CITY OF ALBUQUERQUE

August 5, 2015

**Re: Dreamstyle Warehouse, 1525 Renaissance
Grading and Drainage Plan
Engineer's Stamp Date 7-21-2015 (F16-D051A)**

Based upon the information provided in your submittal July 23, 2015, the above referenced plan is approved for Building Permit based on the following condition:

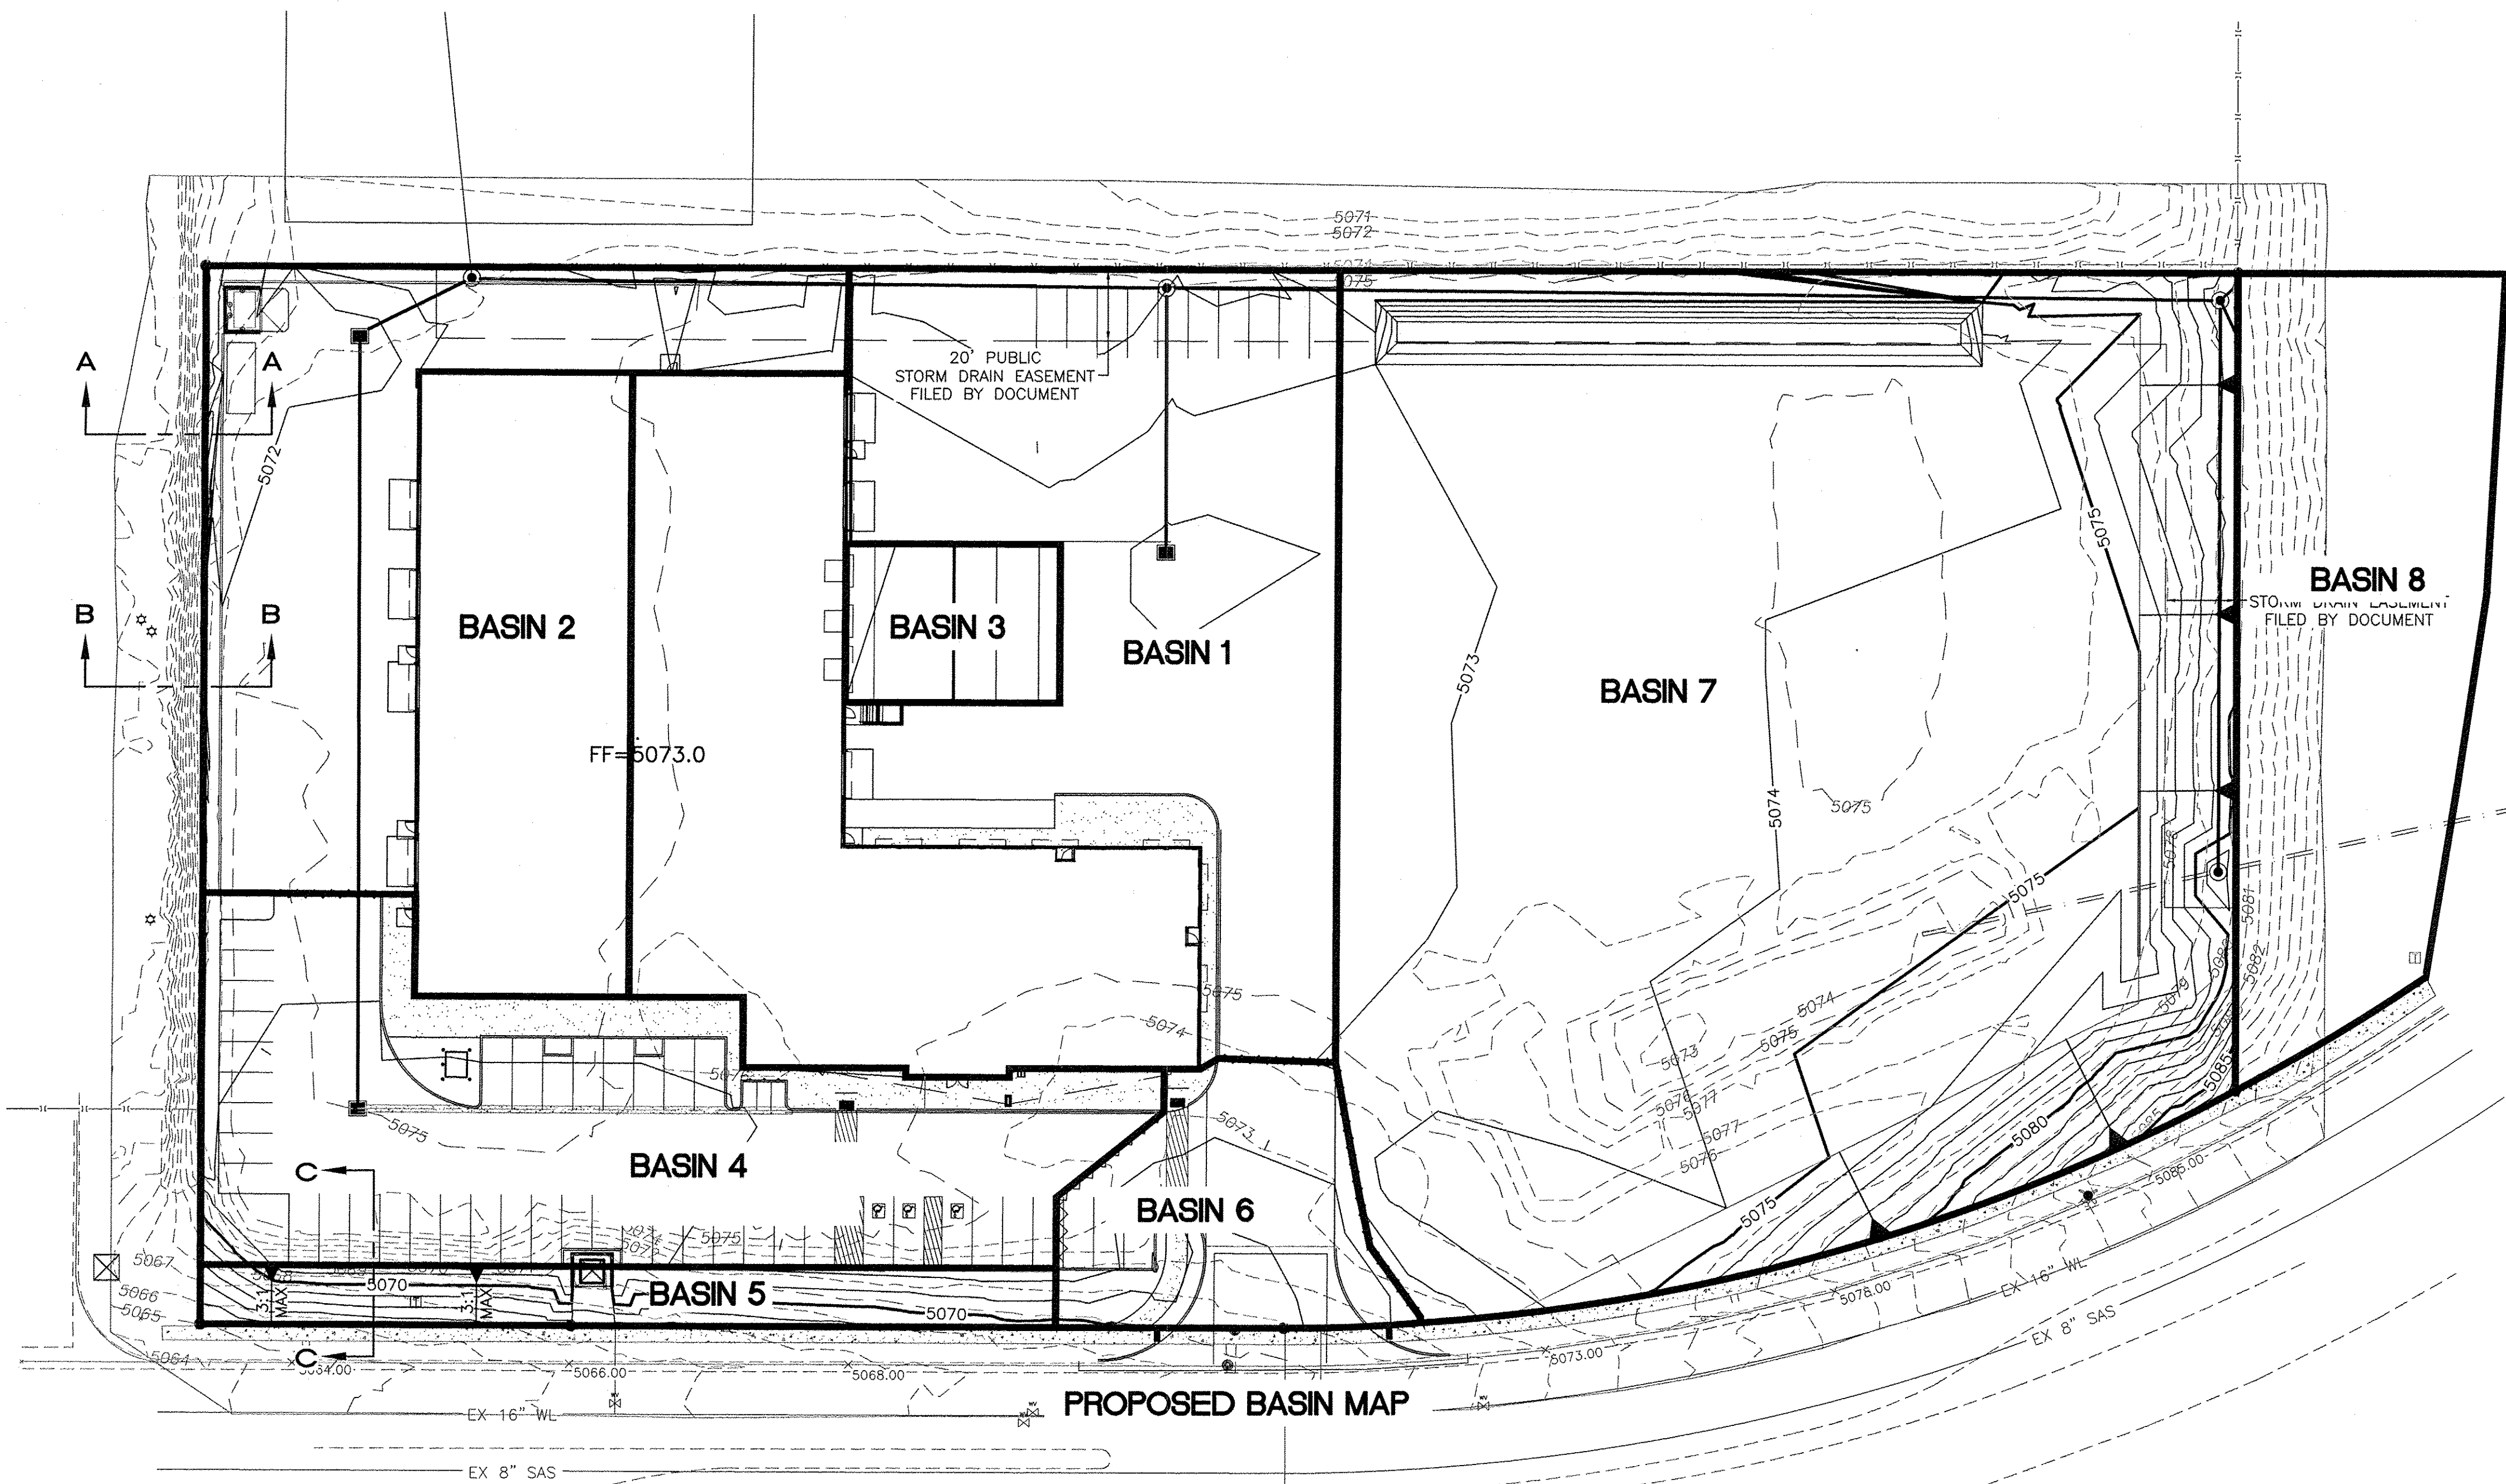
- A recorded "Drainage Easement" for the conveyance of offsite runoff via storm drain pipe across this site will be required prior to Certification of Occupancy.
